From: Sean Garrick <[REDACTED]>
Sent: 30 January 2020 14:49
To: Zac Denton <Zac.Denton@arun.gov.uk>
Cc: Duncan Campbell <[REDACTED]> Melanie Campbell <[REDACTED]>
Subject: R/285/19/HH - 17 Glenville Road Rustington

R/285/19/HH - 17 Glenville Road Rustington (single storey rear extension)

With regard to the above project my client (in the spirit of being neighbourly) has instructed me to reduce the bulk of the extension located within the outrigger as indicated on the revised drawings 1934-03D and 1934-04D enclosed.

Scale 1:50 @ A1 Date AUGUST 2019 Drawing Number 1934-03C

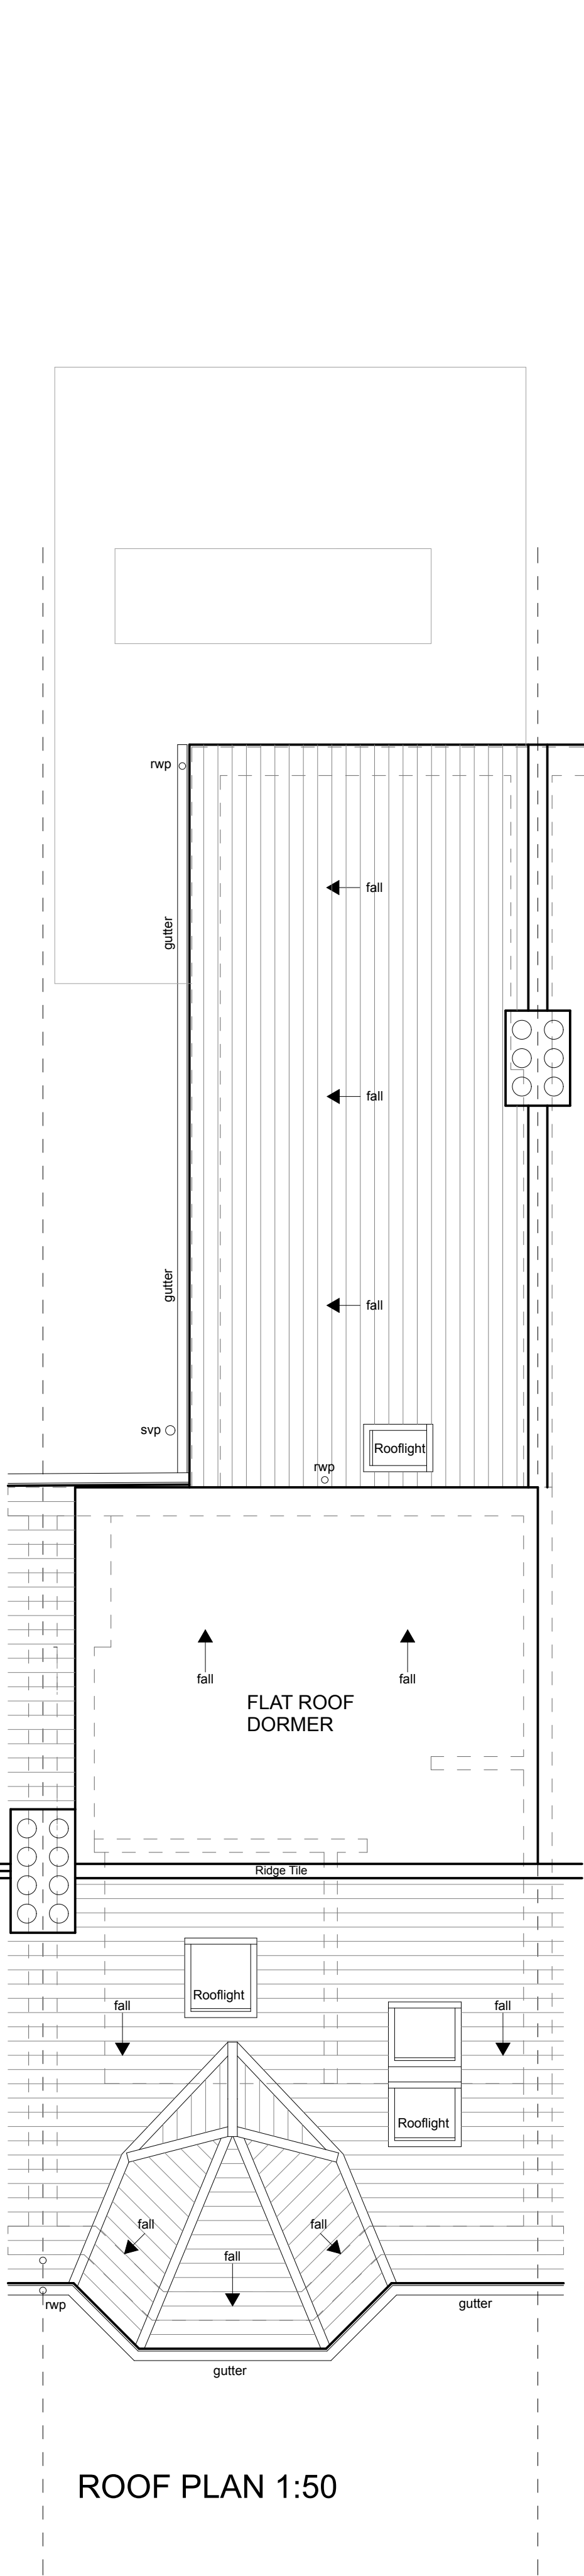
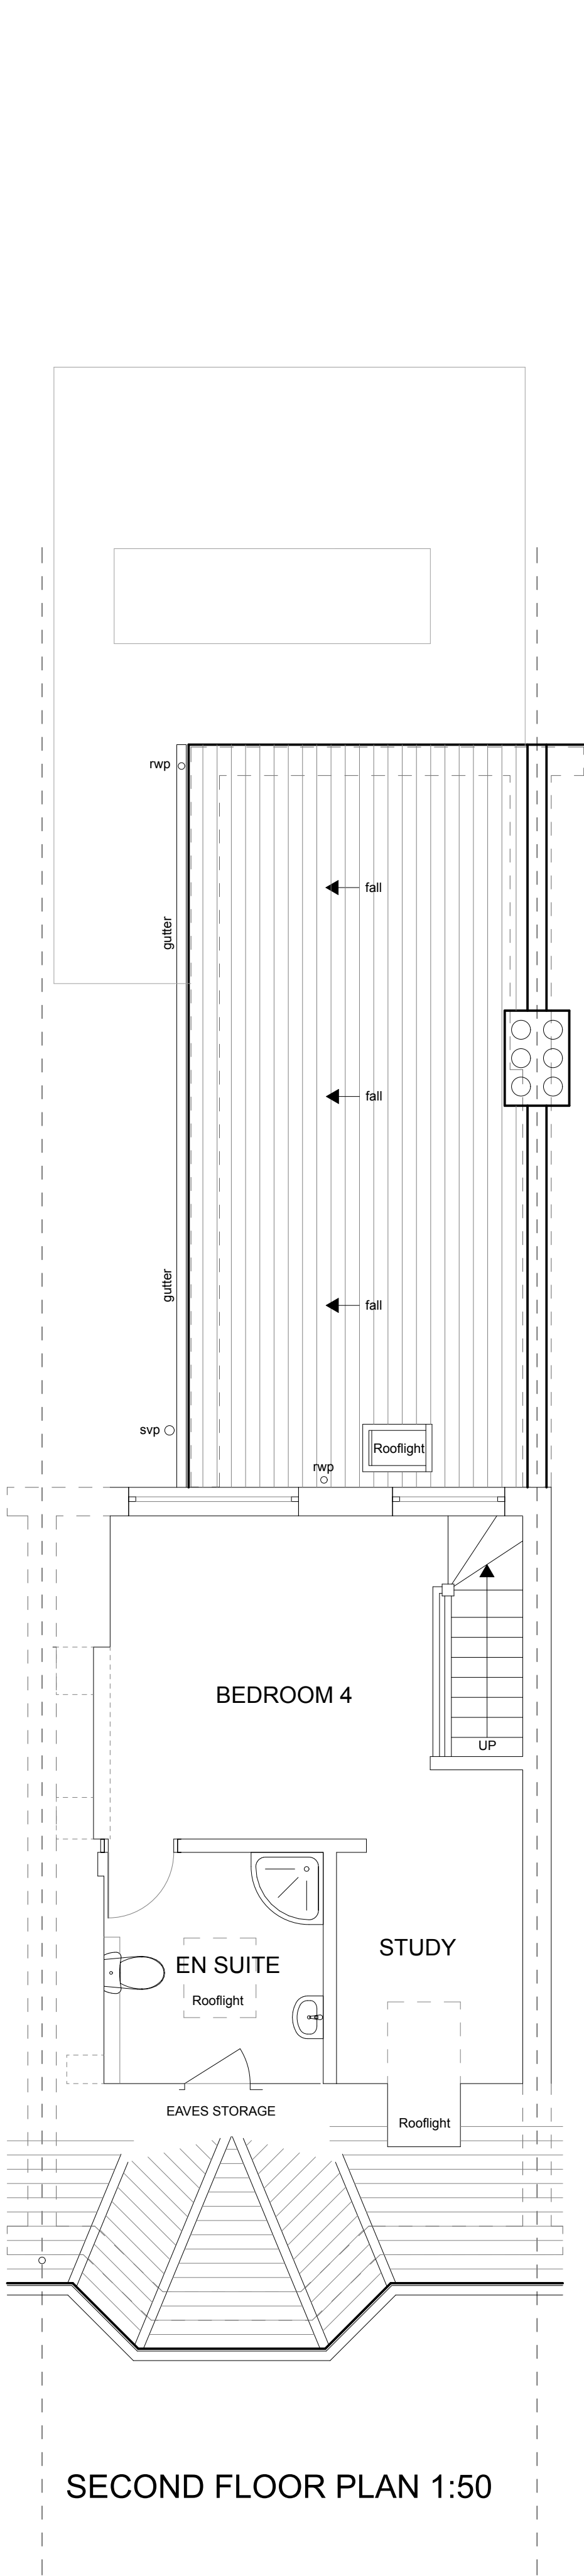
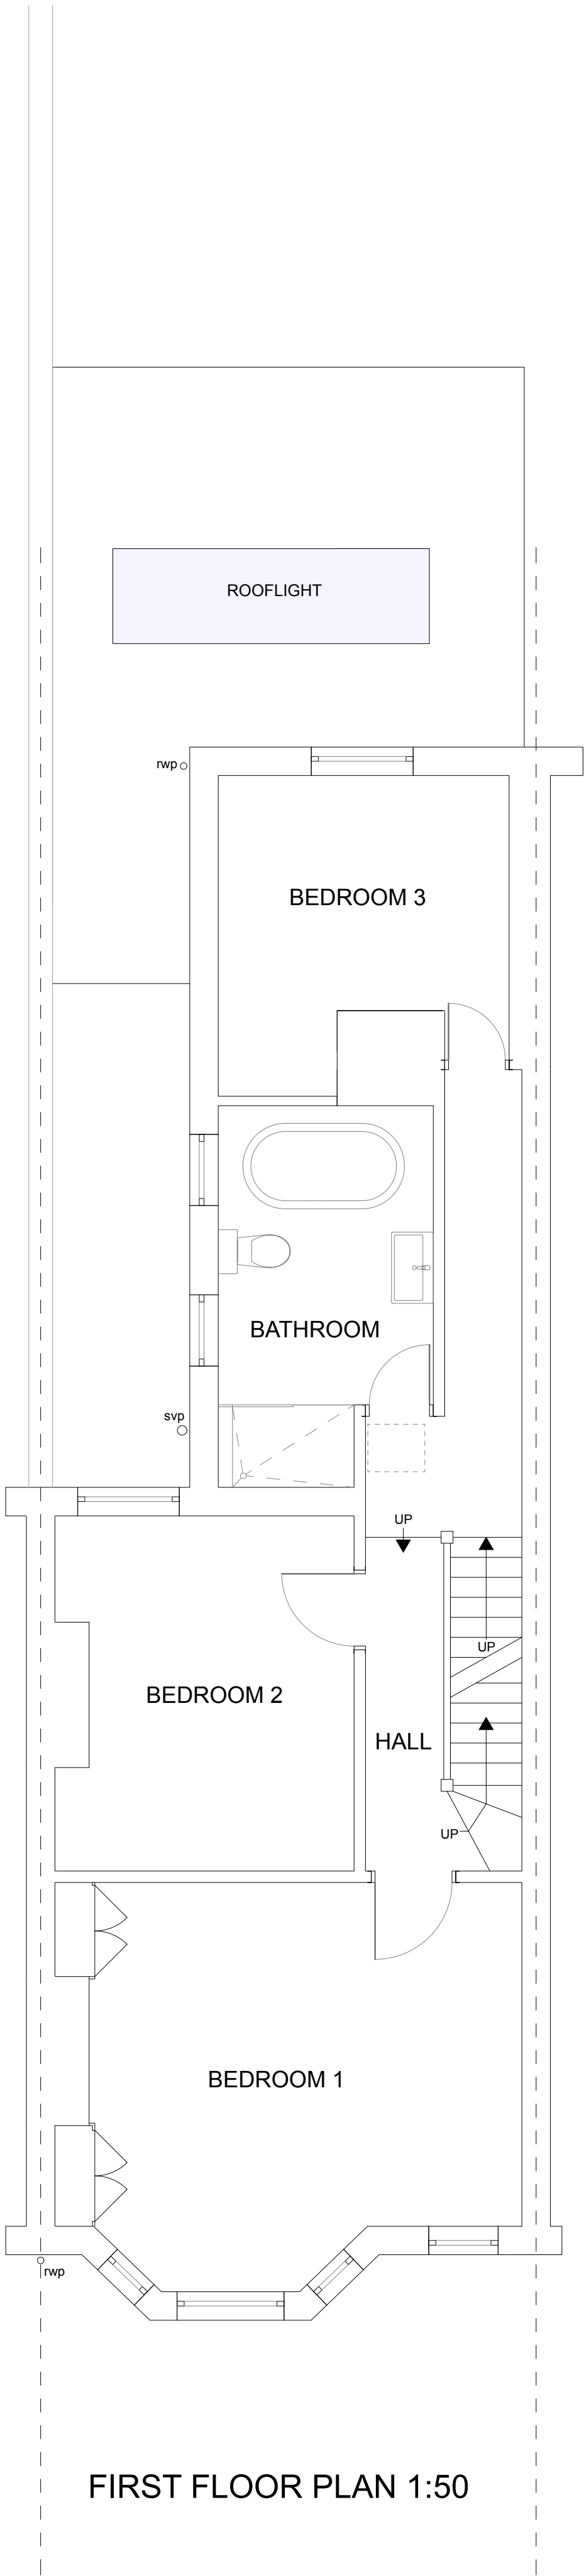
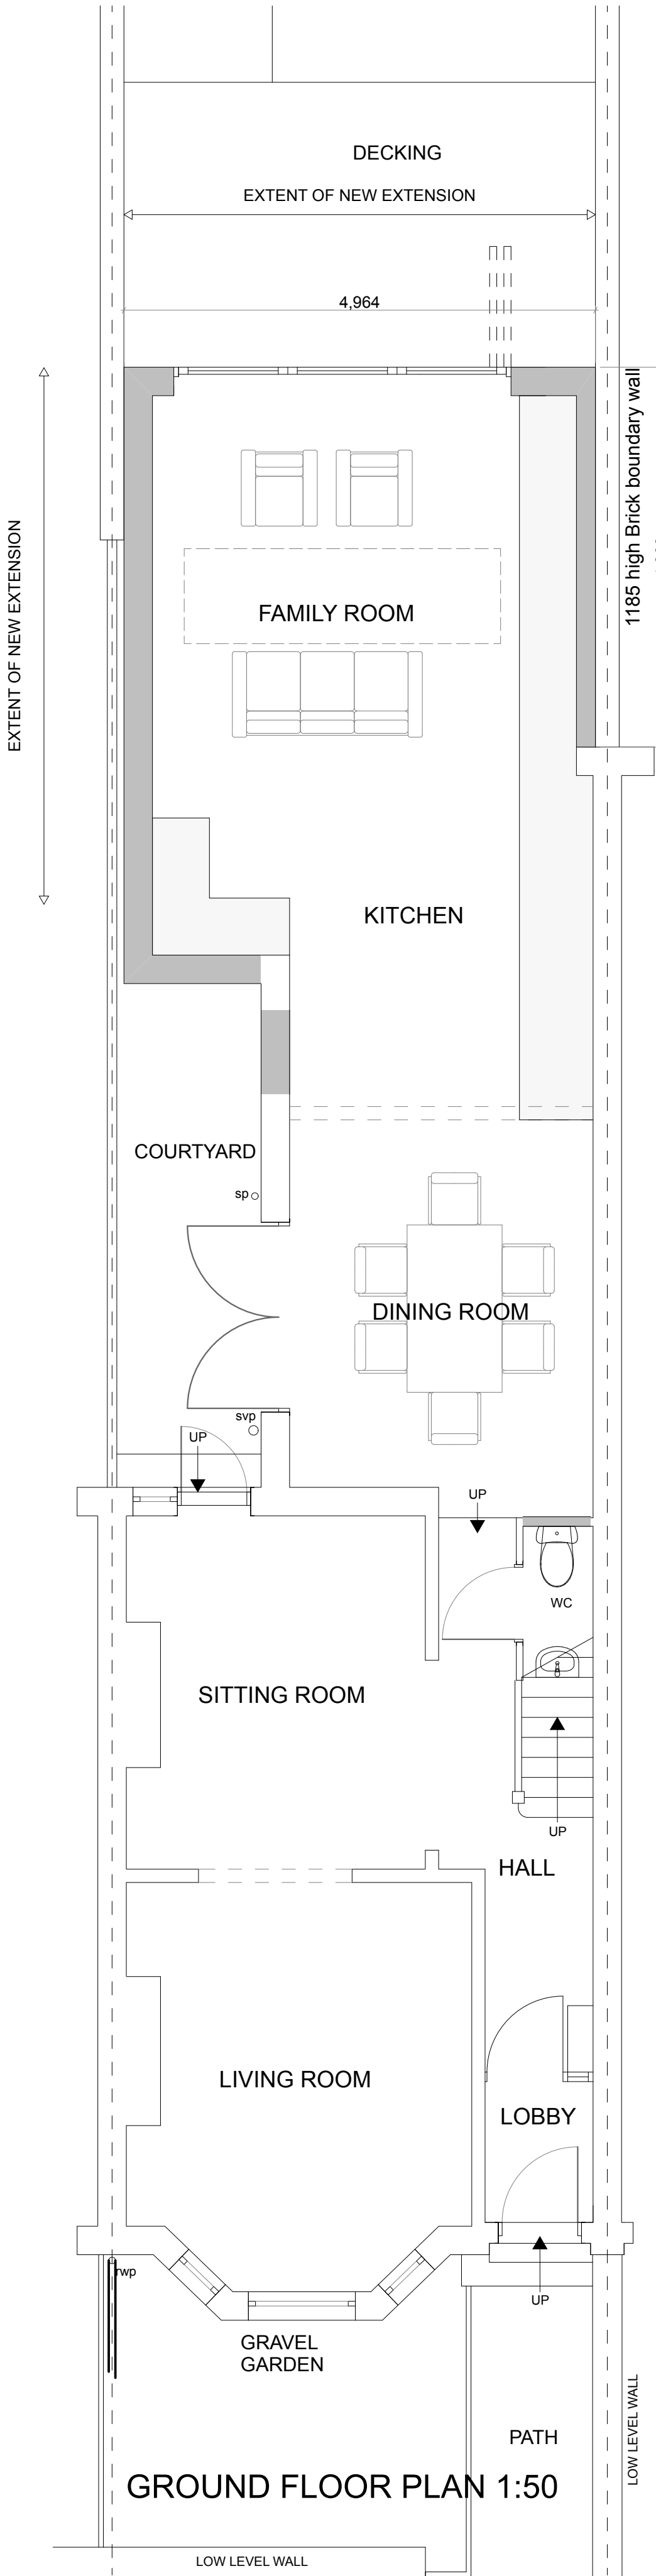
I received a note from my neighbours in no.15 wanting to discuss the extension with me rather than e mailing objections to the Council, which I appreciate.
Whilst they have no objections to the main part it is the return down the side that was concerning them.

Light is a major issue as these North rooms are dark and their large side window would effectively be looking at a solid wall. I fully appreciated their concerns - I would have had the same, roles reversed.

I like our neighbours and do not wish to upset the apple cart for a few extra feet. Is it possible to amend the plans so that the extension purely covers the back of the house and not down the side return?

The side door in the kitchen (leading out to the Courtyard) will remain blocked up as on the plans but both of the single windows will be re instated. Finally, could we have a fully glazed window/ door looking into/ down the Courtyard from the new extension.

Happy new year and thank you for your e mail.
I have now amended the drawing which you may wish to further discuss with your neighbour.
I've adjusted the rooflight position to suit the revised shape of the room.
I would be tempted to introduce a window to the courtyard elevation within the existing door location.
